**re: Geotechnical Review – Site Servicing Plan**  
Proposed Mix-Use Development  
1131-1151 Teron Road - Ottawa

**file:** PG5283-MEMO.03

Paterson reviewed the following drawings prepared by WSP for the proposed mix-use development to be located at the aforementioned site as part of the geotechnical assessment:

- Project No. 20M-01534-00 – Servicing Plan – Drawing No. C03 Revision 2, dated September 3, 2021.
- Project No. 20M-01534-00 – Proposed 250mm W/M Extension in Teron Road – Drawing No. C03A, dated September 3, 2021.

C03A

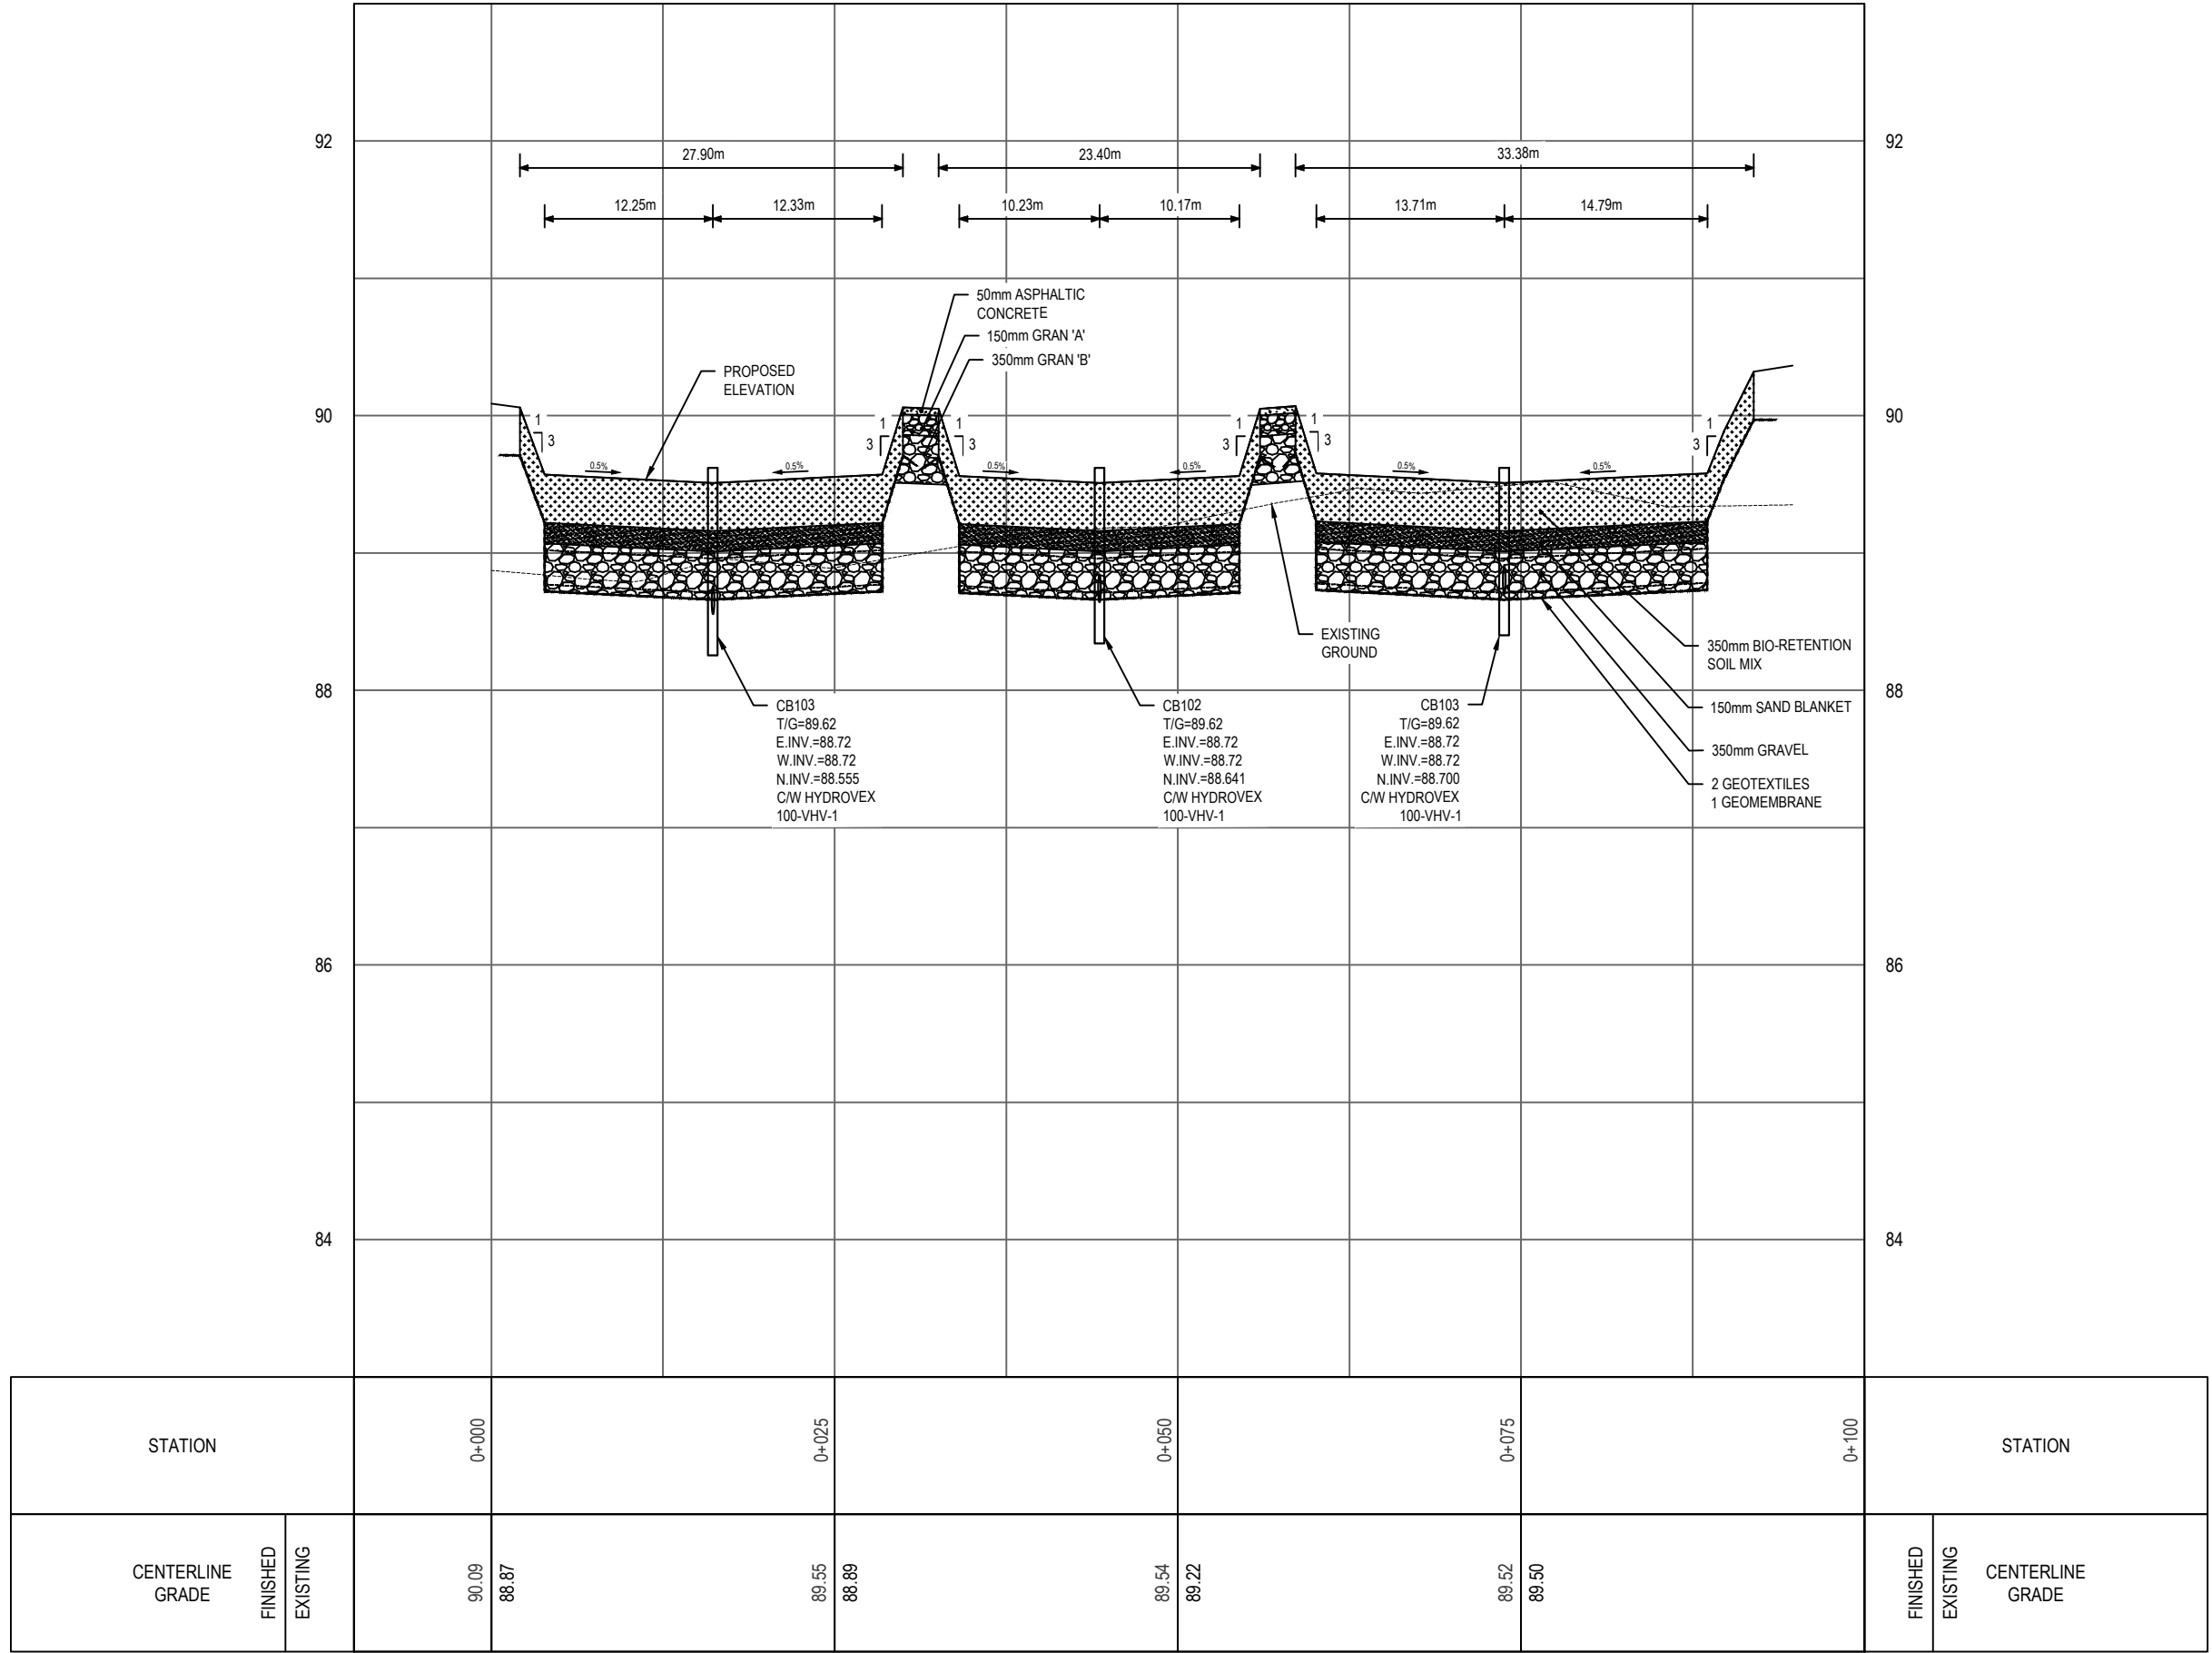
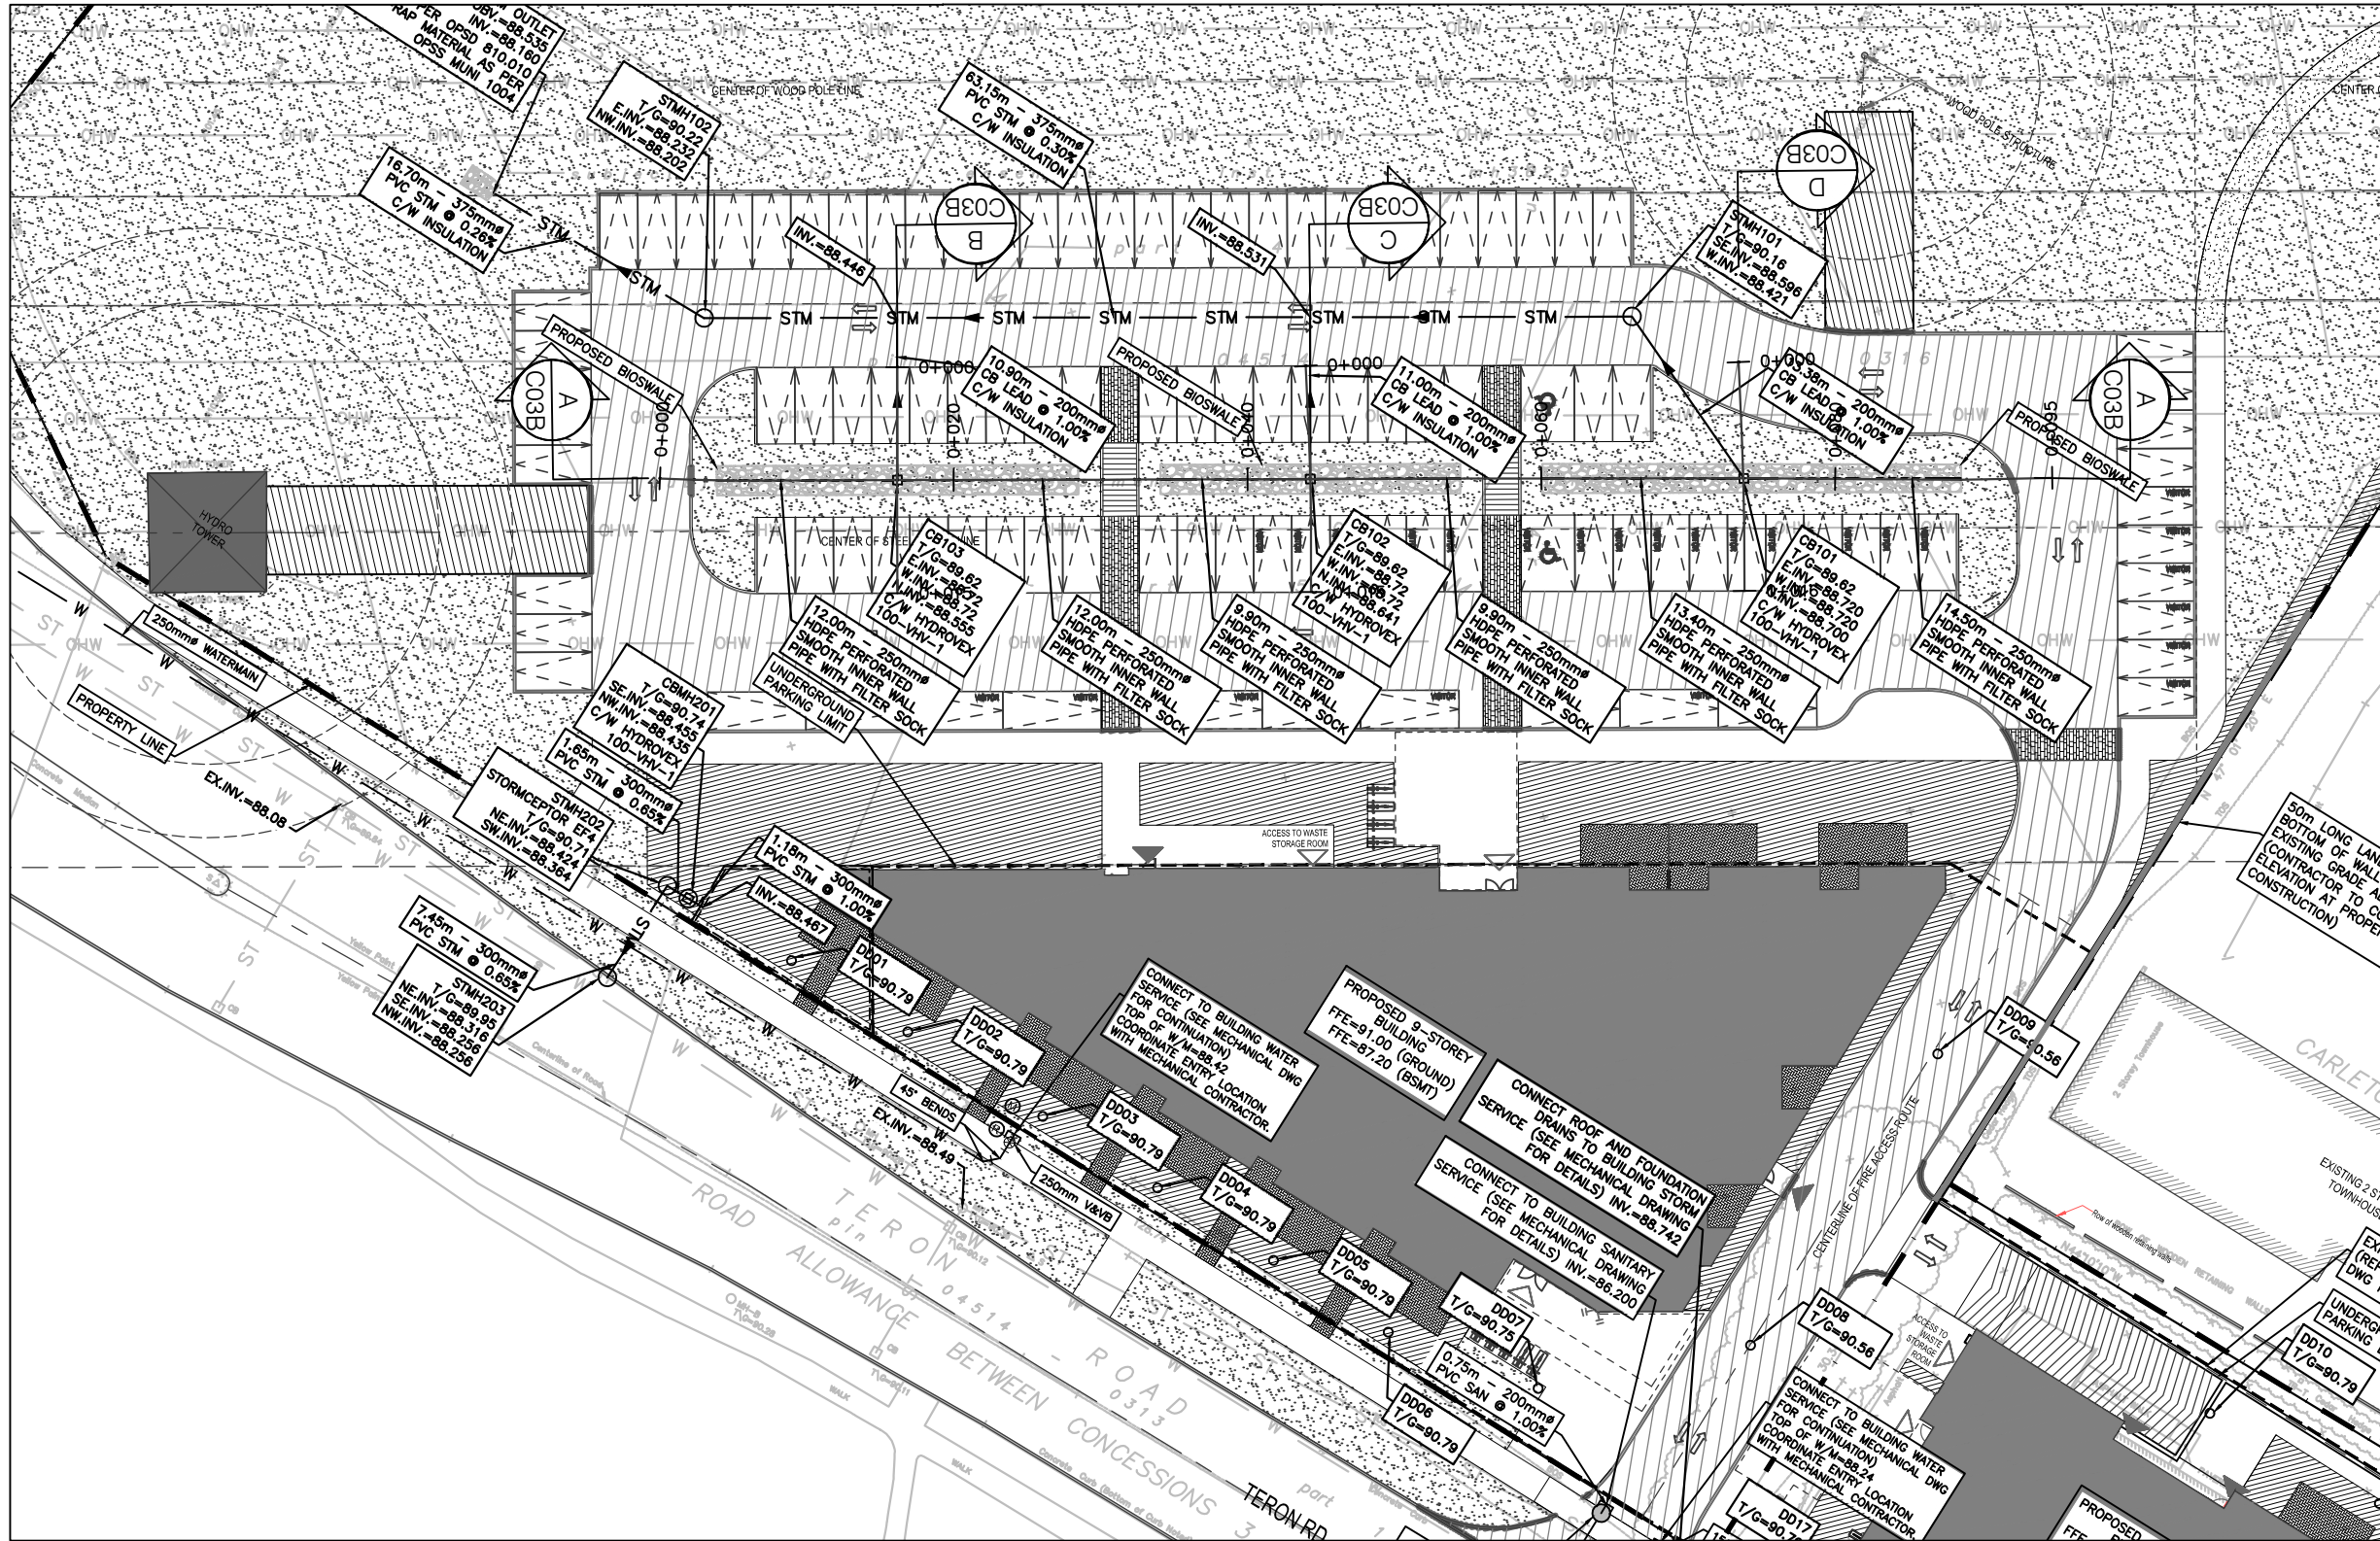
The proposed watermain which runs parallel to the southwestern property boundary is to be connected to the existing 305mm diameter watermain running across the intersection between Teron Road and Steacie Drive. The proposed 250mm watermain was observed to cross below an existing storm pipe which runs from Teron Road towards March road, with a vertical separation of 0.5m. Furthermore, the proposed watermain was also observed to cross below a proposed storm pipe which connects the proposed storm chamber cistern located along the west corner of the 9 storey building to the existing storm pipe along Teron Road. The proposed watermain and proposed storm pipe will have a vertical separation of 0.94m. On the other hand, the proposed 250mm watermain was observed to cross above an existing 605mm watermain with a vertical separation of 0.35m.

The proposed sanitary pipe which runs from the central portion of the south property boundary and runs perpendicular to Teron Road is to be connected to the existing sanitary pipe located along Teron Road at an invert level of 72.44m. The proposed 200mm sanitary pipe was observed to cross below an existing watermain and storm pipes with unknown invert levels running parallel to the near lane of Teron Road and an existing storm pipe with unknown invert level running parallel to the farthest lane of Teron Road.

- Extra precautions should be taken during excavation around and below the existing services where the proposed watermain/sanitary pipes will be crossing below the existing storm sewer and watermain. It is suggested that hand digging or using a 'hydrovac' technique be used when excavating in close proximity to the existing storm sewer and watermain to avoid any potential damage to the existing mainline pipes. It is expected that pipe bedding below the proposed service alignments will be in accordance with the recommendations provided in Paterson Report PG5283-1 Revision 1 dated September 20, 2021.

- The excavated area below the existing storm sewer and watermain should be reviewed by the geotechnical consultant and backfilled with an unshrinkable fill (0.3 to 0.5 MPa - compressive strength). The unshrinkable fill should in-fill the excavated area adjacent to the installed watermain/sanitary sewer and extend vertically to the invert level of the existing storm sewer and watermain pipe and horizontally to the supported sides of the excavation. Furthermore, the unshrinkable fill shall extended horizontally beyond the face of the existing service pipes a minimum distance of 300 mm. The unshrinkable fill should be placed against a clean, excavation sidewall face to eliminate any voids that may cause settlement issues.

- Temporary support for the existing watermain will be required to protect the pipe from hanging without support for too long. Refer to the attached City of Ottawa Drawing
